TfNSW reference: REN25/00086/005

Your reference: SSD-72430958

**SSD-72430958, Finley Battery Energy Storage System - Various Lots, Berrigan Shire Council;
Response to Submissions**

This attachment relates to TfNSW's response dated 2 April 2026 reference REN25/00086/005.

CLIENT	GRANSOLAR DEVELOPMENT AUSTRALIA PTY LTD	JOB CODE	P001993_01
PROJECT	FINLEY BESS	SHEET NUMBER	C003
LOCATION	RIVERINA HIGHWAY, FINLEY 2713	REV	A
SHEET TITLE	VEHICLE TURNING PATHS, SHEET 1 OF 4

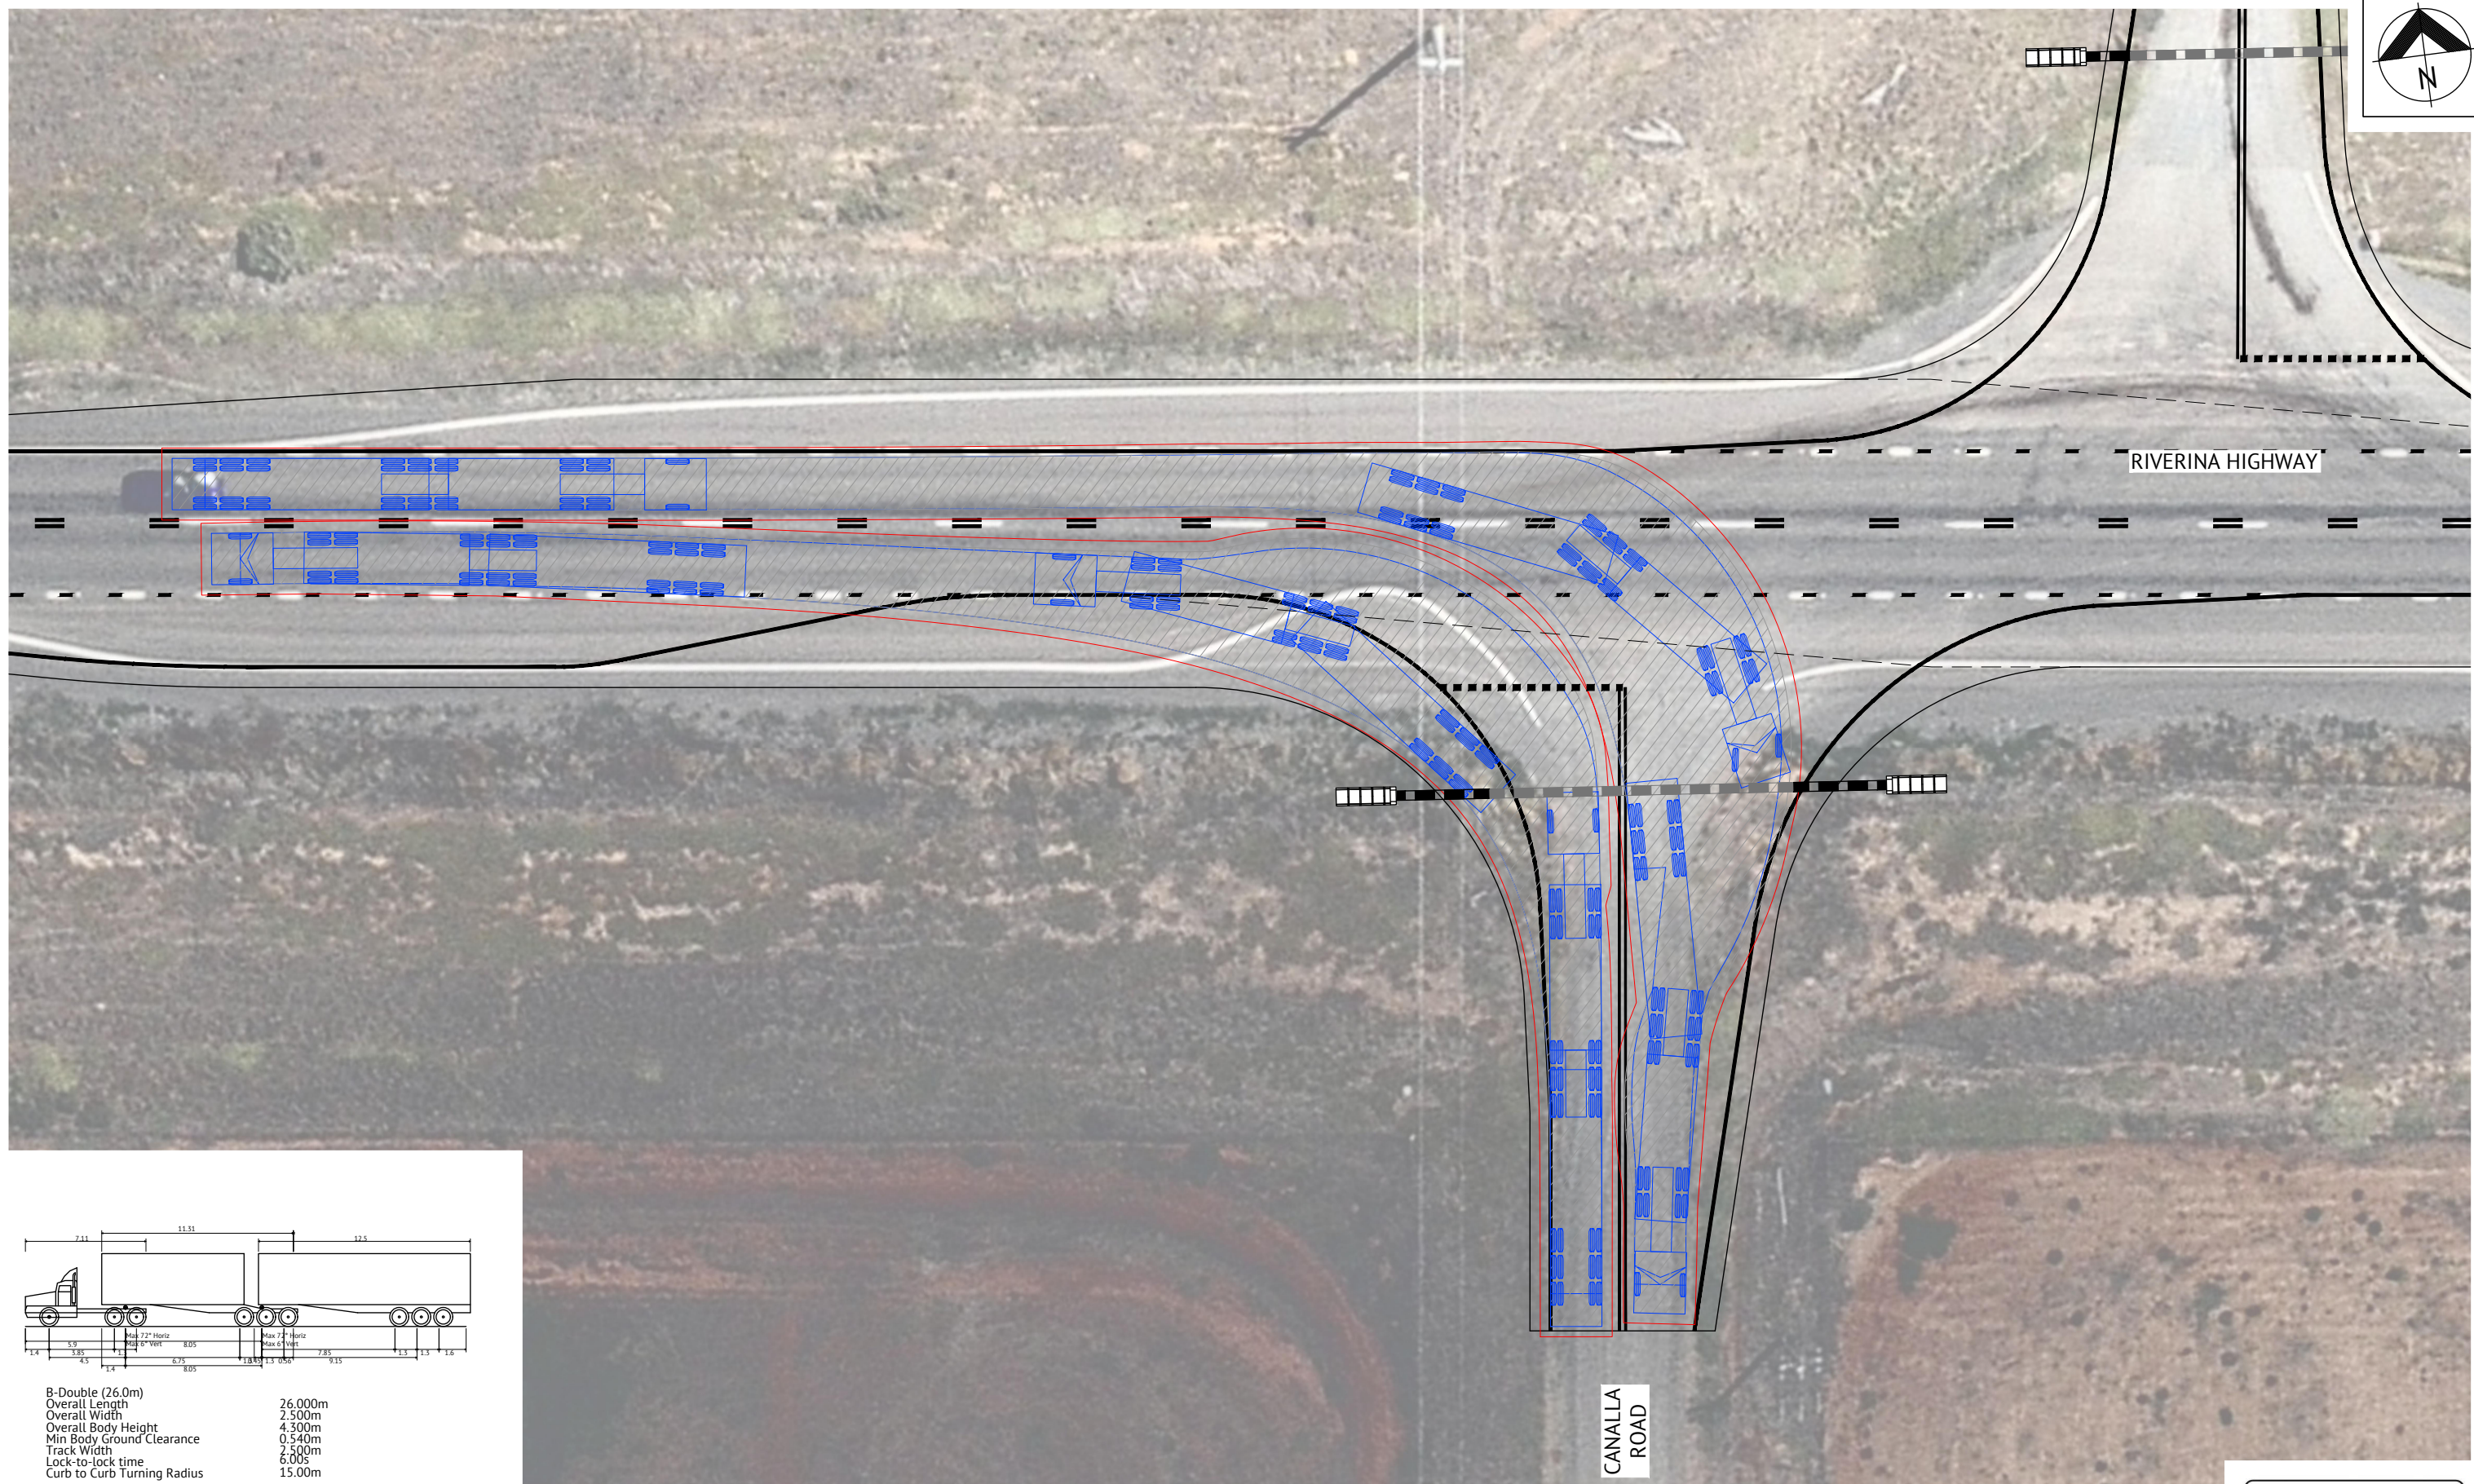
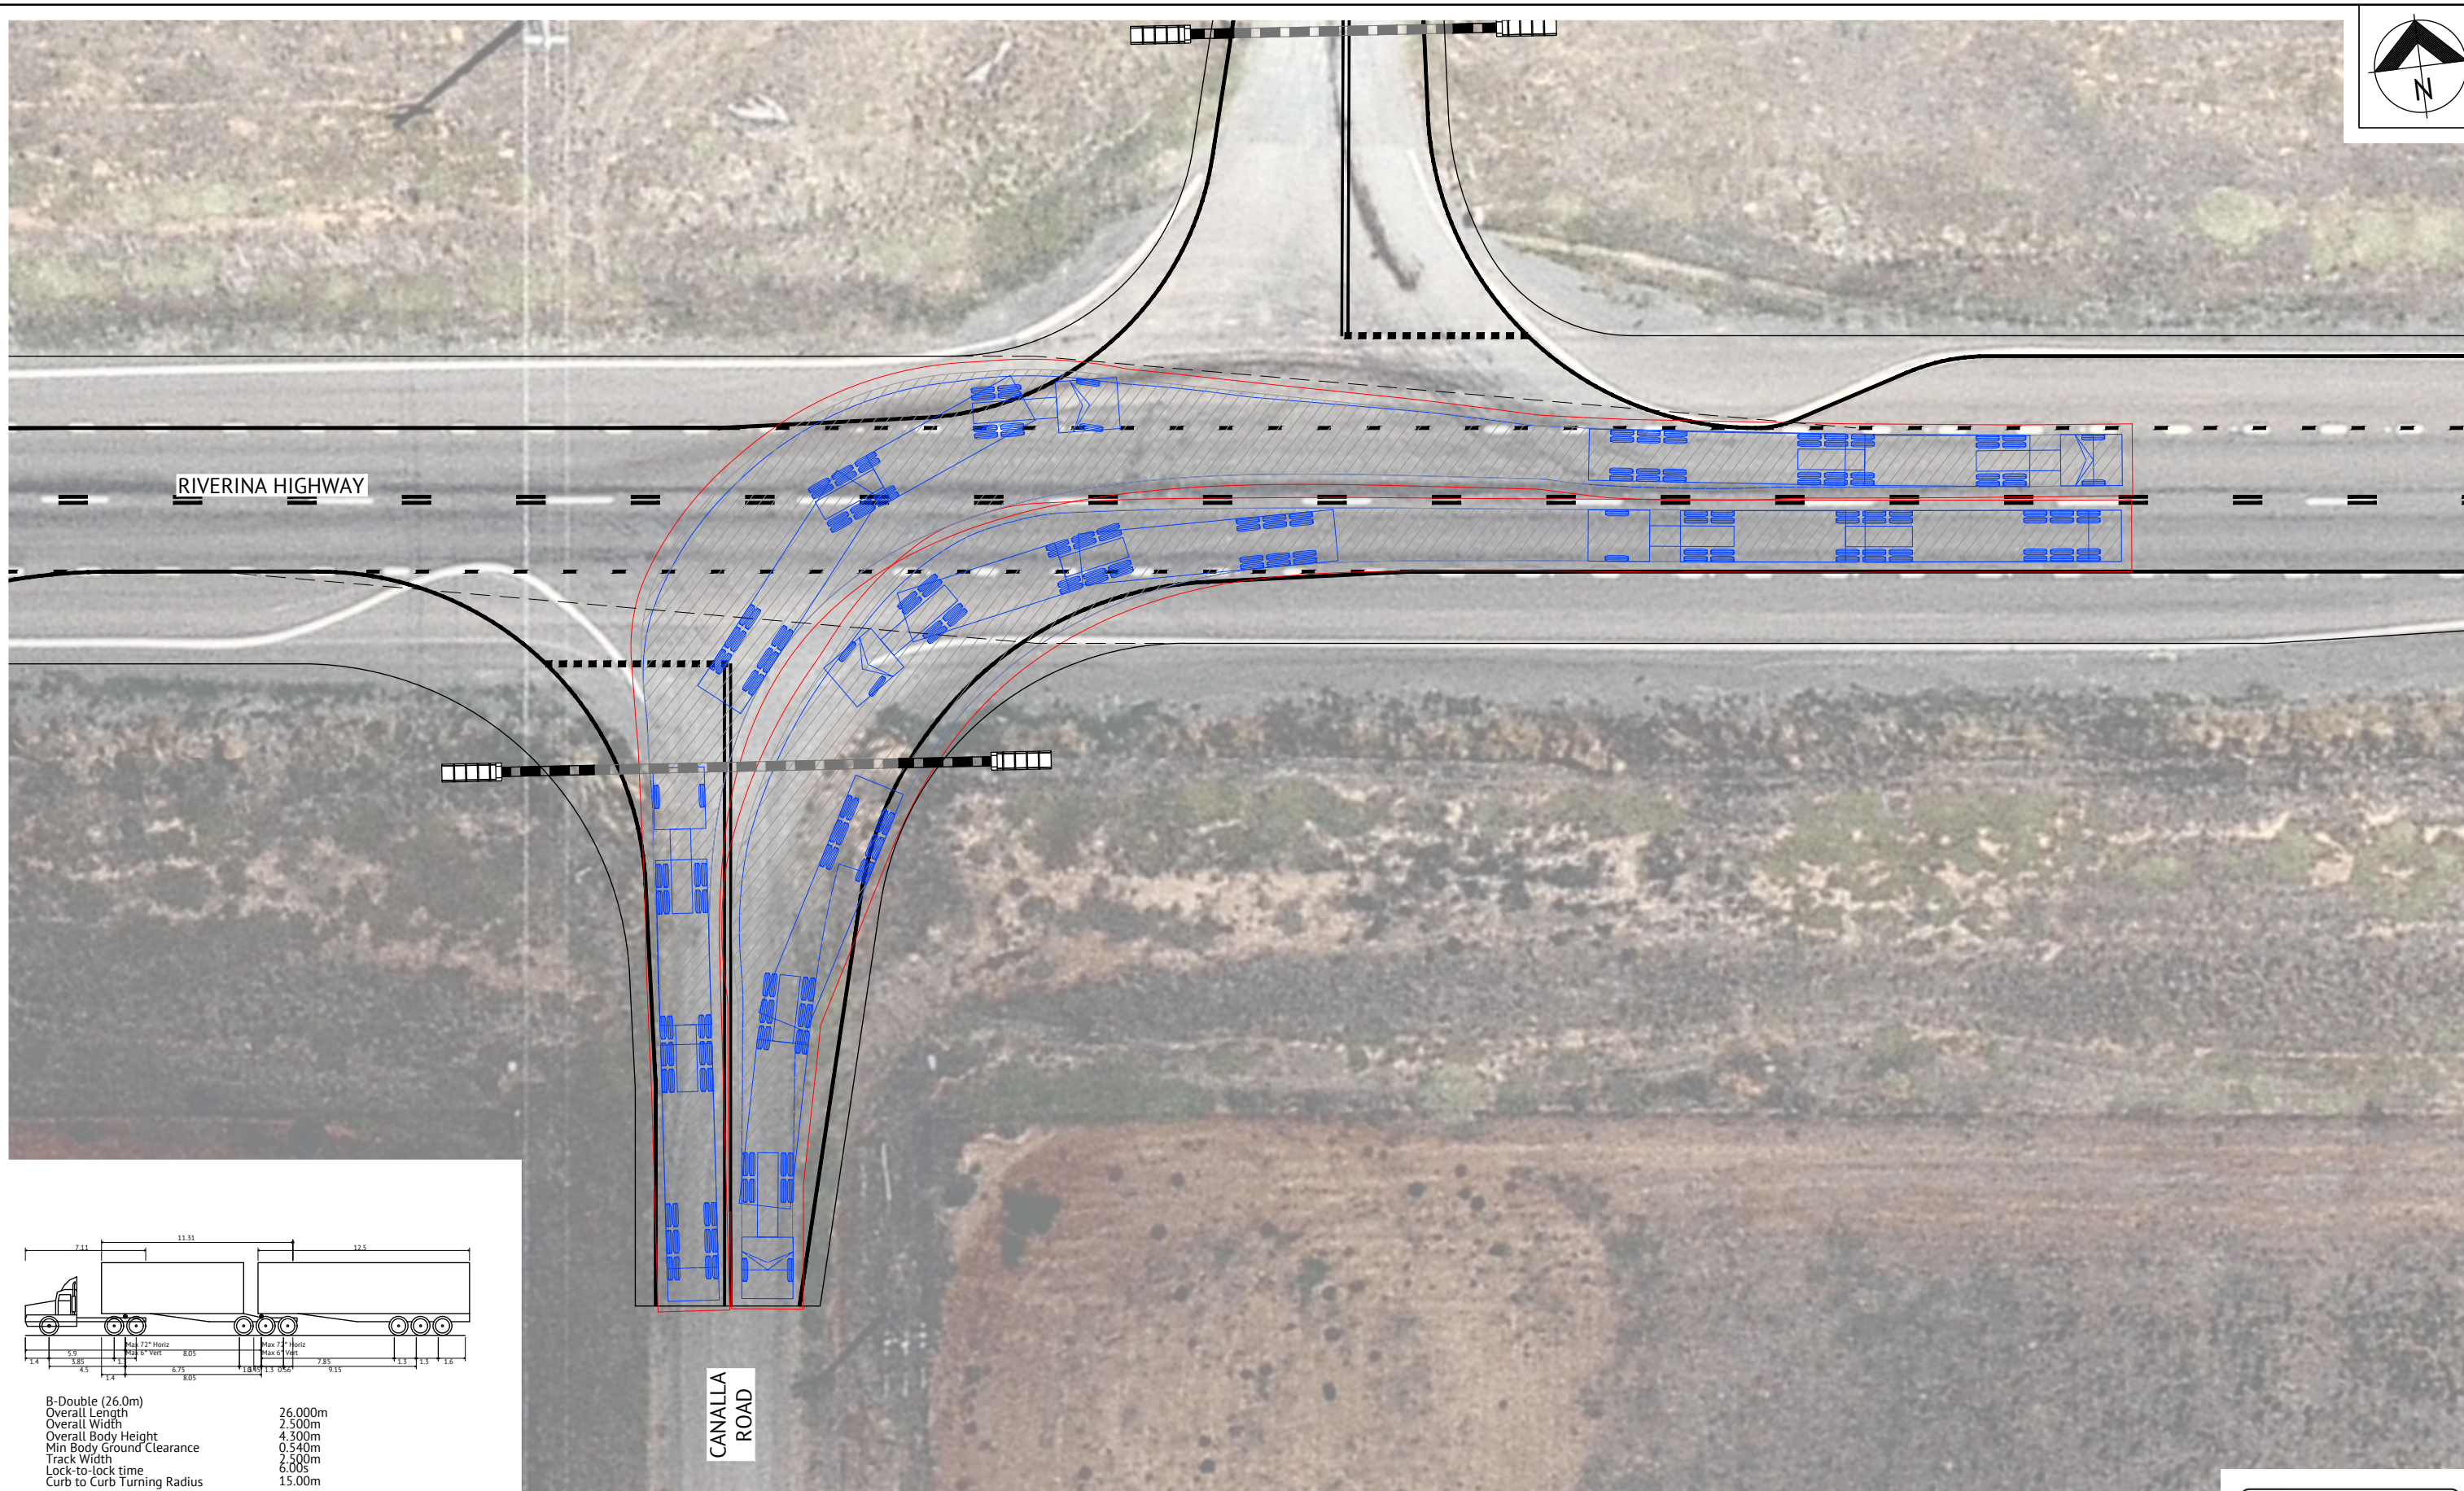
d) Swept Paths Swept paths are required to be provided for the largest heavy vehicle and high-risk OSOM configuration (corresponding to the design and check vehicle) required to use each intersection, access point or navigate pinch points along the high-risk OSOM routes. This must be prepared following Austroads Design Vehicles and Turning Path Templates.	OPEN - The swept path still shows a right-turn movement crossing the Canalla Road centreline. Revise the swept path analysis and consider traffic mitigations to manage the impact to avoid crossing the centreline of Canalla Road. If traffic mitigation measures (i.e., limiting the use of the intersection for construction traffic to one heavy vehicle at a time, turn prohibitions or reduced design vehicle size). The implementation of traffic mitigation measures, enforceability and compliance must be discussed with DPHI to determine the suitability of the proposed measures. If DPHI determines that the proposed traffic management measures are not enforceable, the intersection will need to be widened to accommodate concurrent turn movements within the pavement, without requiring crossing the centreline of Canalla Road.
